From: Amy Myer <Amy.Myer@arun.gov.uk>
Sent: 19 November 2019 11:24
To: Planning.Responses <Planning.Responses@arun.gov.uk>
Subject: FW: EP/116/19/CLE - 29 Tamarisk Way - WITHDRAWAL

In any case, I have been re-assigned your case from my colleague Richard, and have now had chance to review the details. I note the building is on the Local List, and is within an Area of Special Character, but is not within a Conservation Area.

LAWFUL DEVELOPMENT			
Elevations as proposed			
date: Aug 19			
scale: 1:100@ A1	1905	AL	(0-) 06

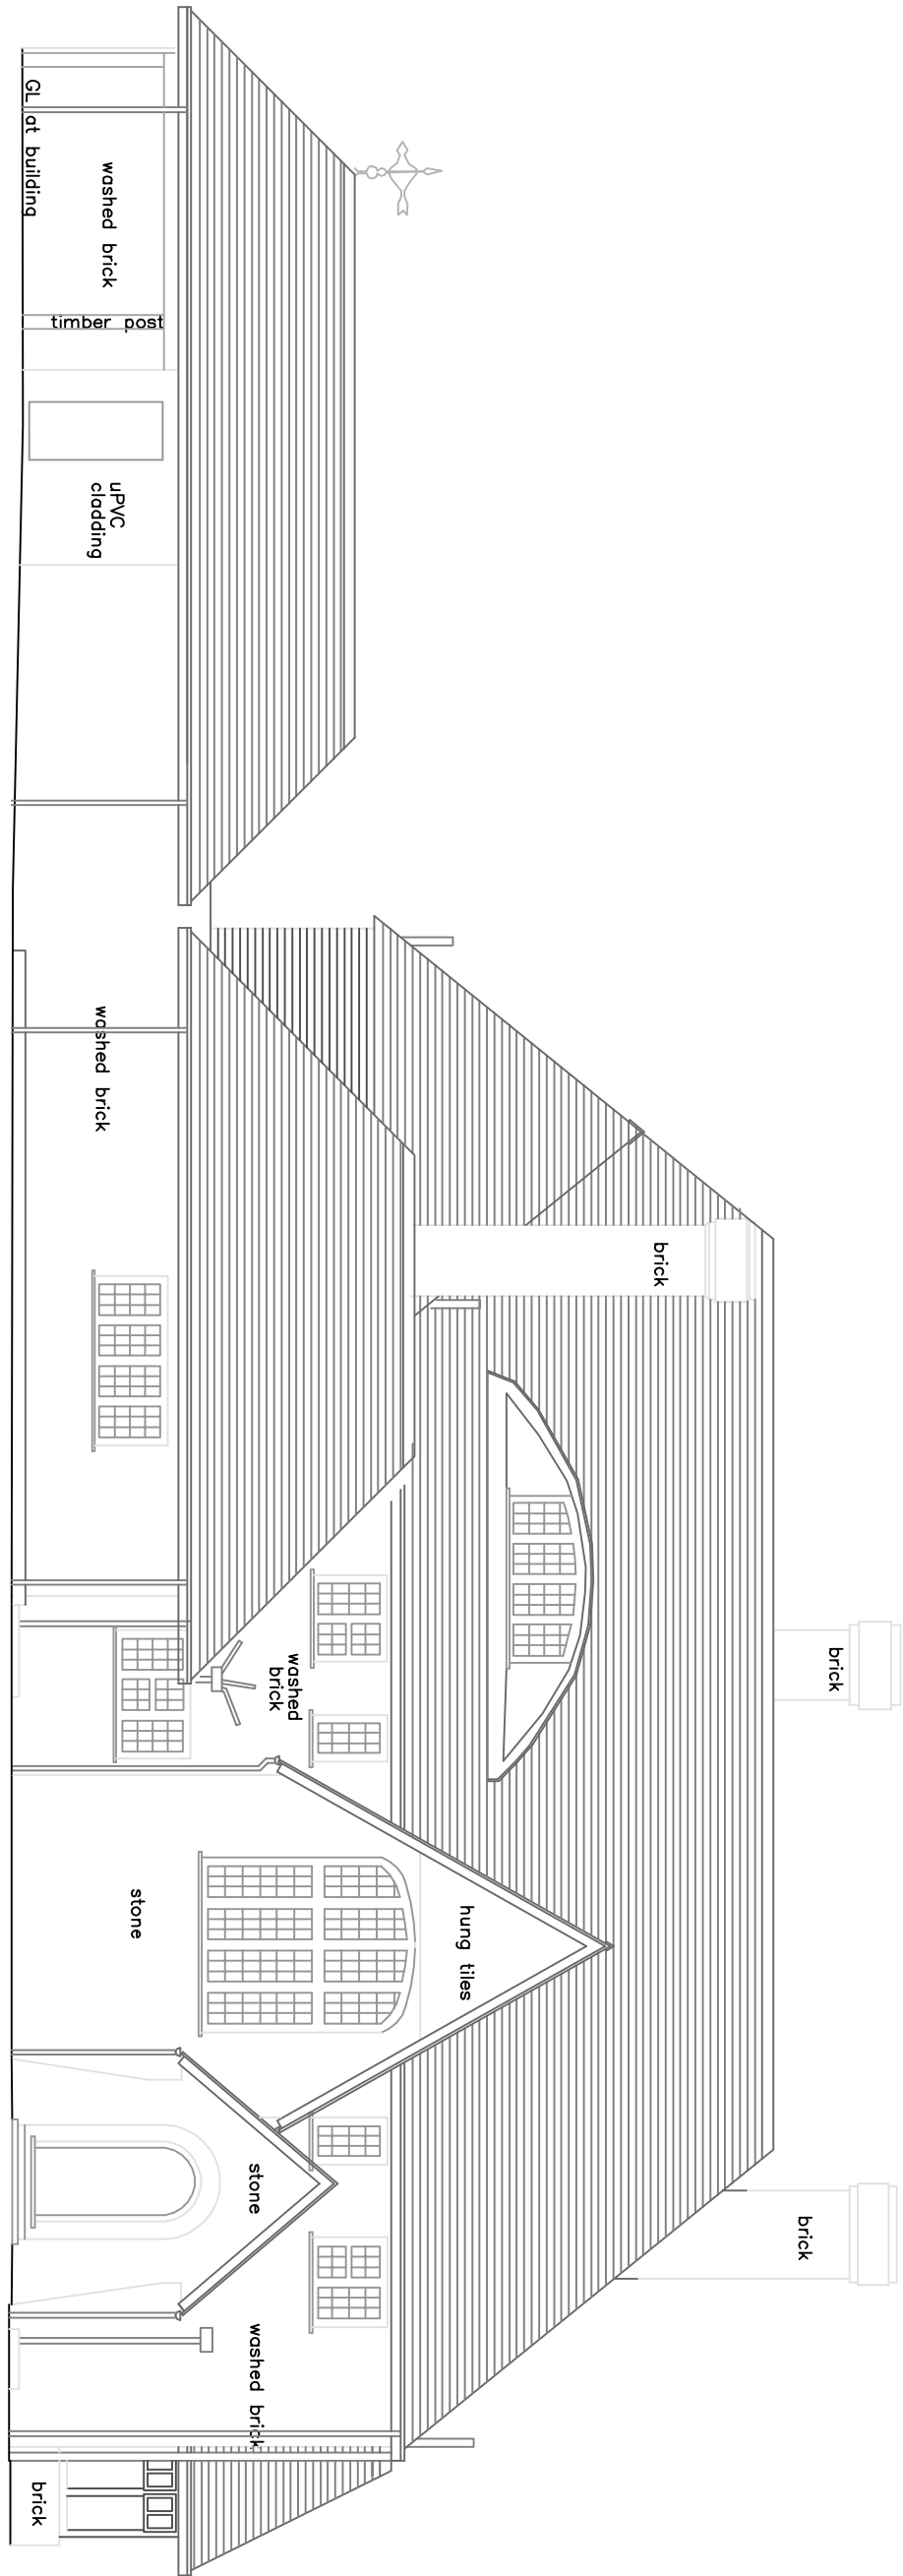
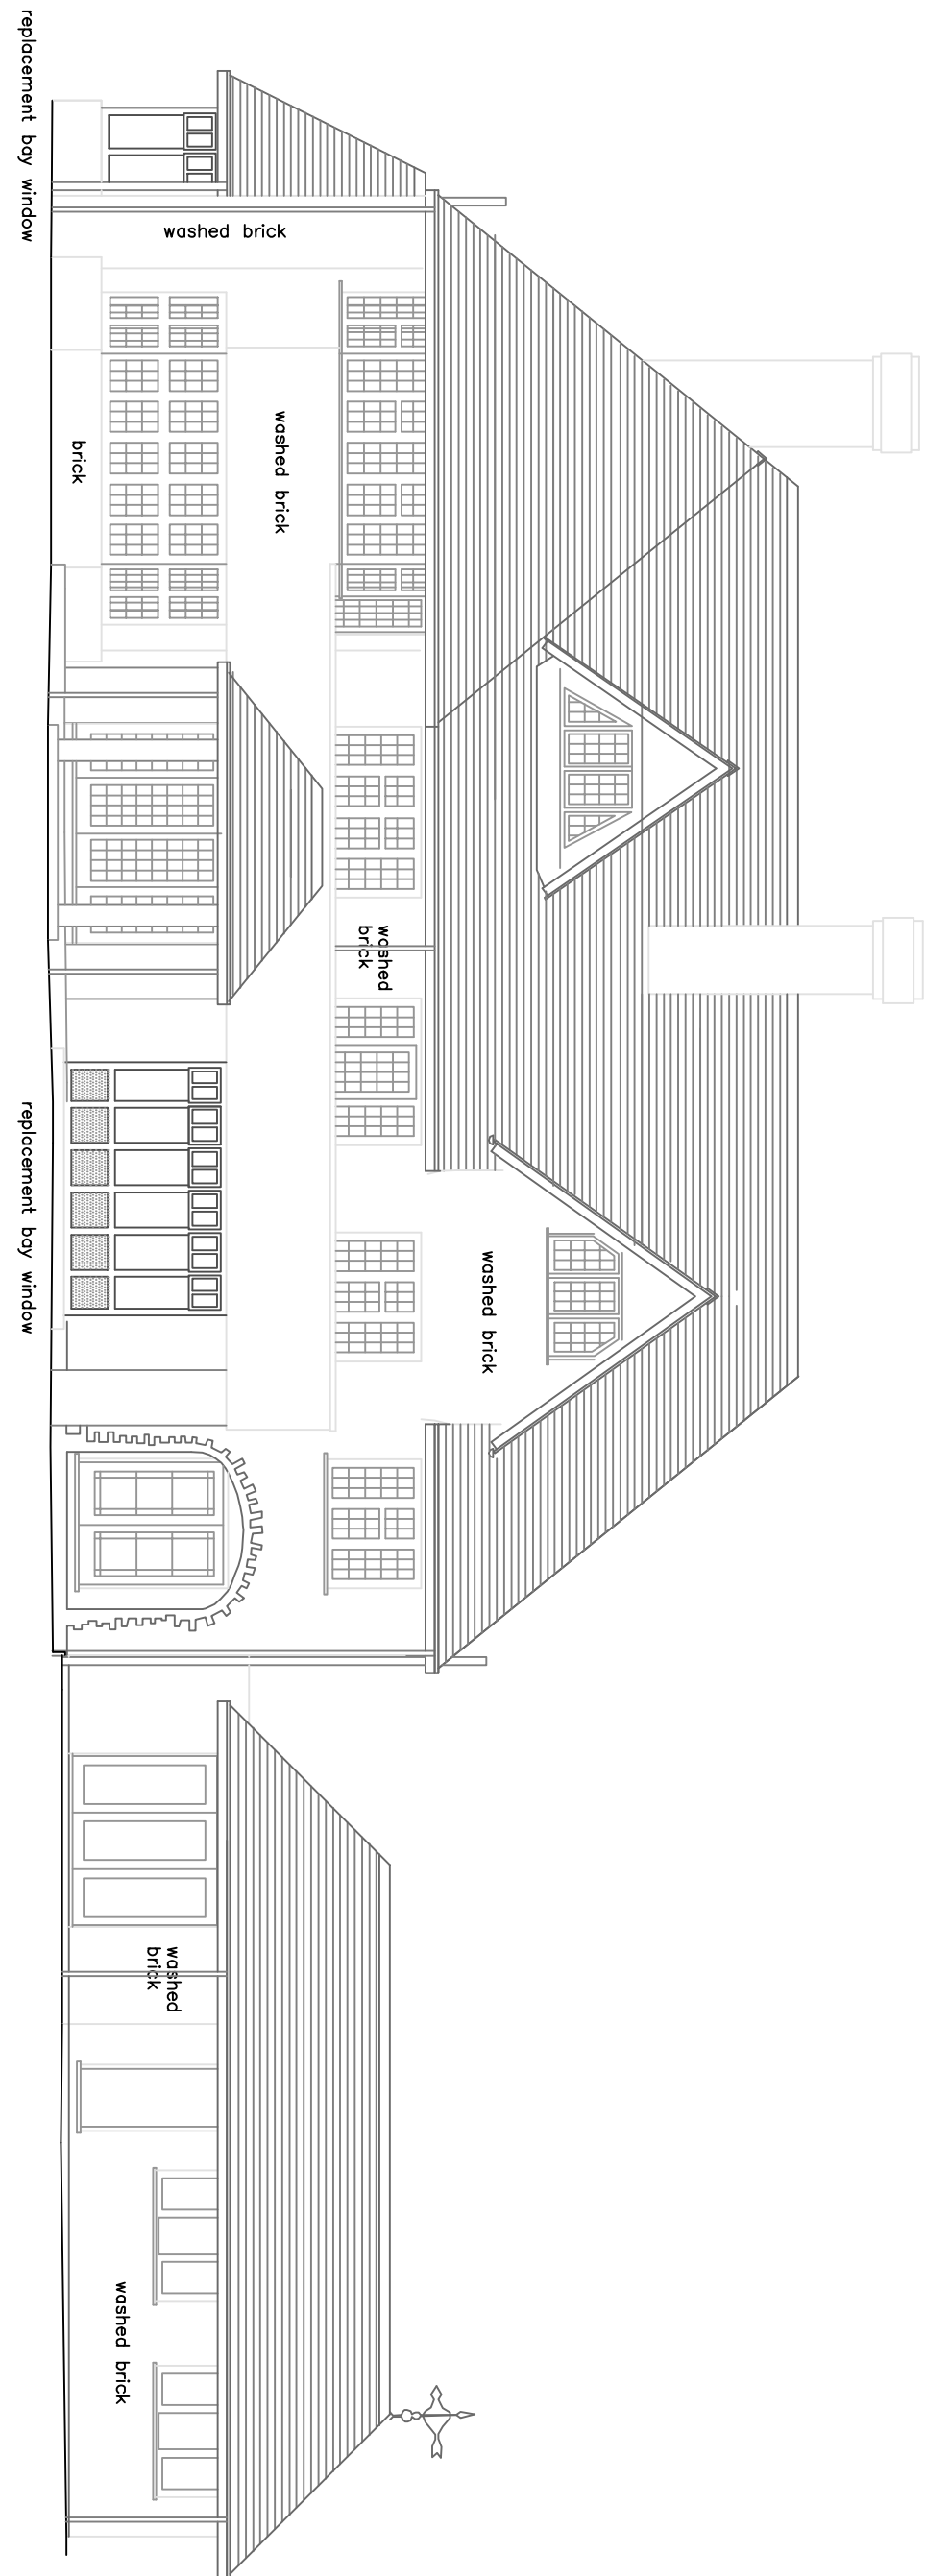
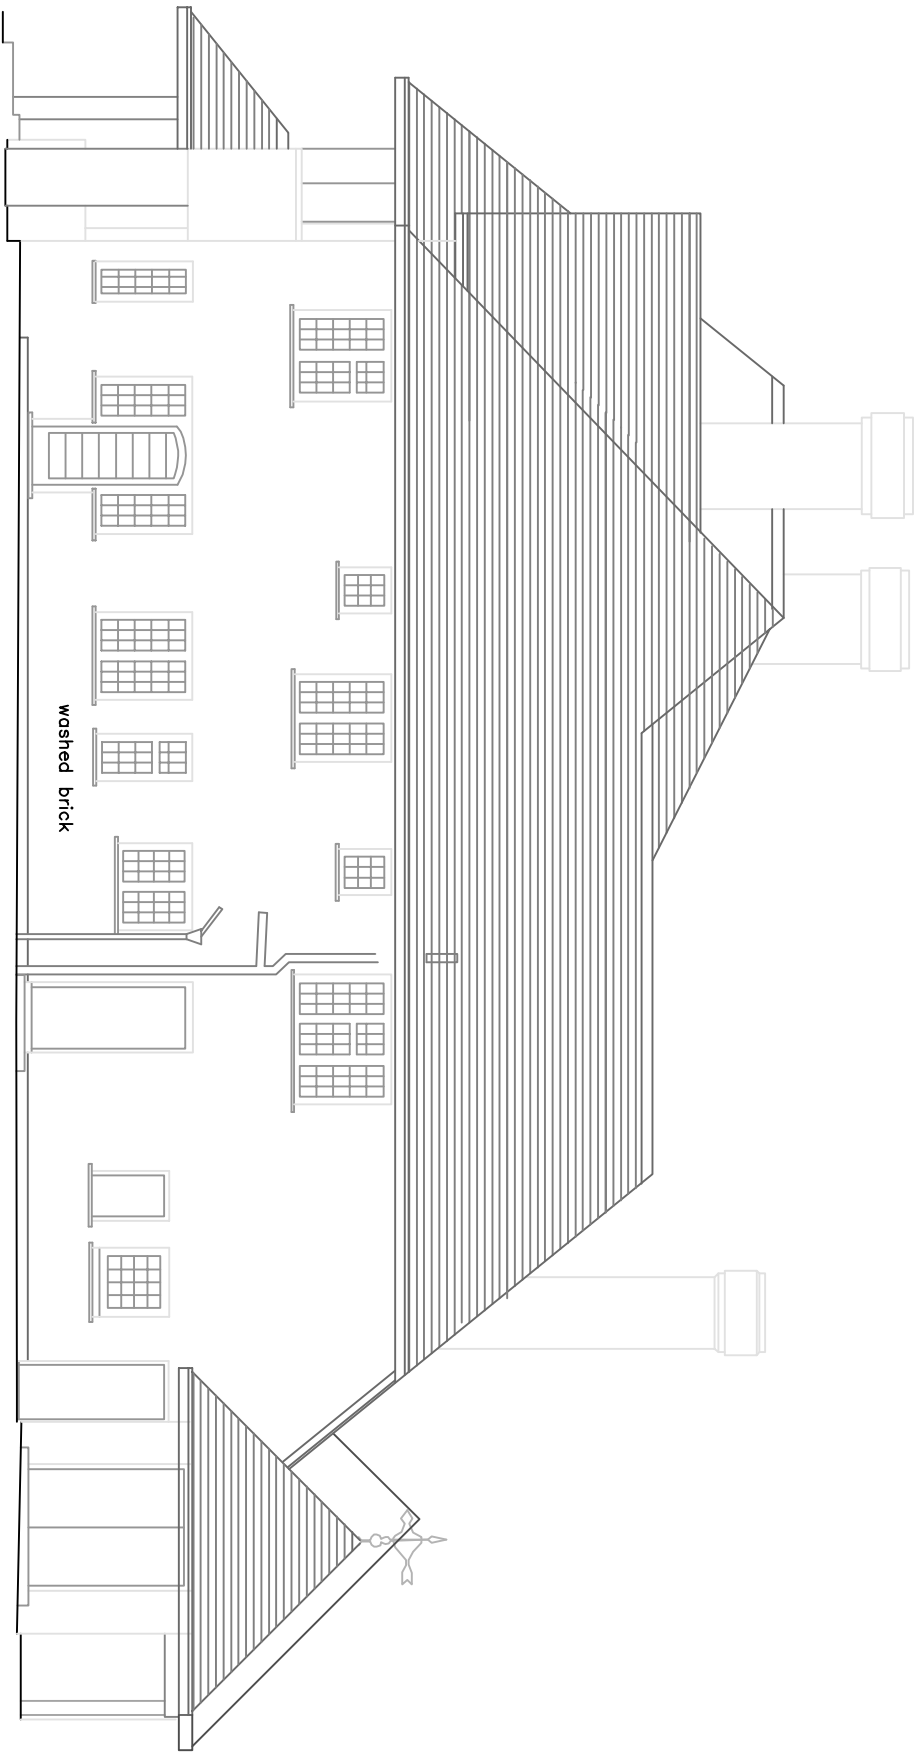
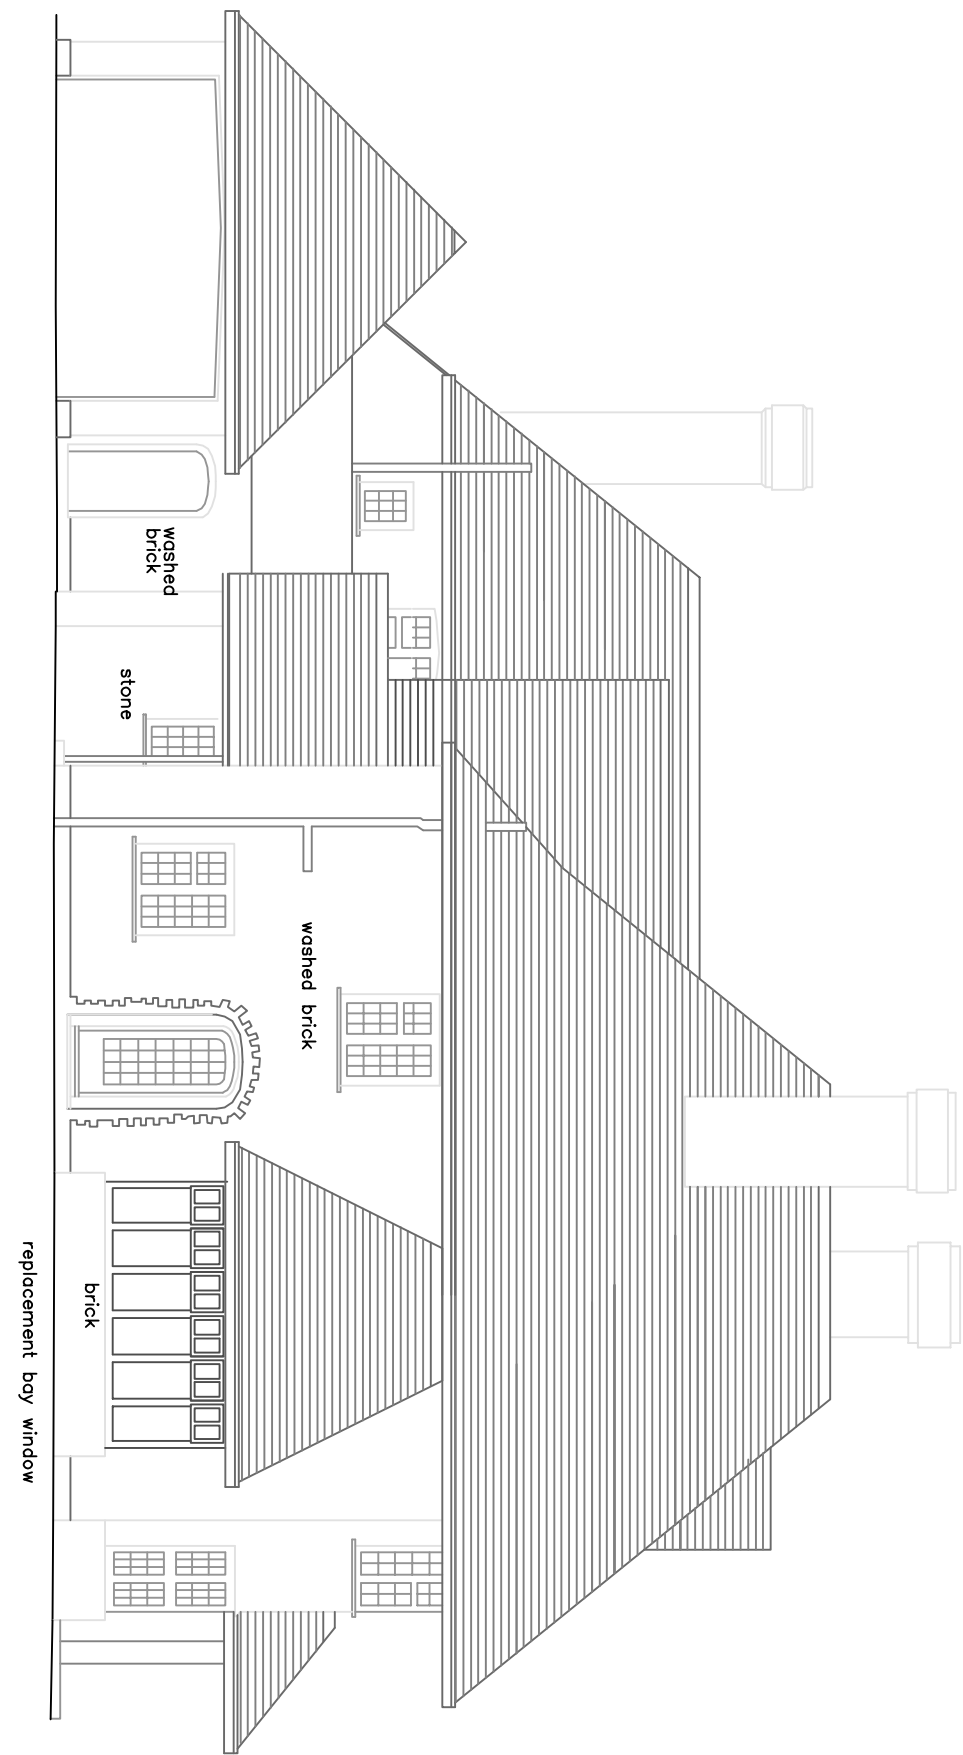
- Replacement of the existing thatched roof with clay tiles – would fail Condition A.3 of Class A and Condition B.2 of Class B of the GPDO (2019) which requires that *“the materials used in any exterior work...shall be of a similar appearance to those used in the construction of the exterior of the existing dwellinghouse”* – clearly clay tiles could not be deemed as being sufficiently similar in visual appearance to thatching
- The replacement bay window on the side elevation (which would be treated as an ‘extension’ and thus fall under Class A) – would fail Condition (j, i) of Class A of the GPDO which states that if *“the enlarged part of the dwellinghouse would extend beyond a wall forming a side elevation of the original dwellinghouse, and would – i) exceed 4 metres in height”* will not be permitted

Also, regarding the replacement bay windows - neither the application form, nor the drawings confirm the proposed materials so I am unsure whether the proposal would comply in this respect?
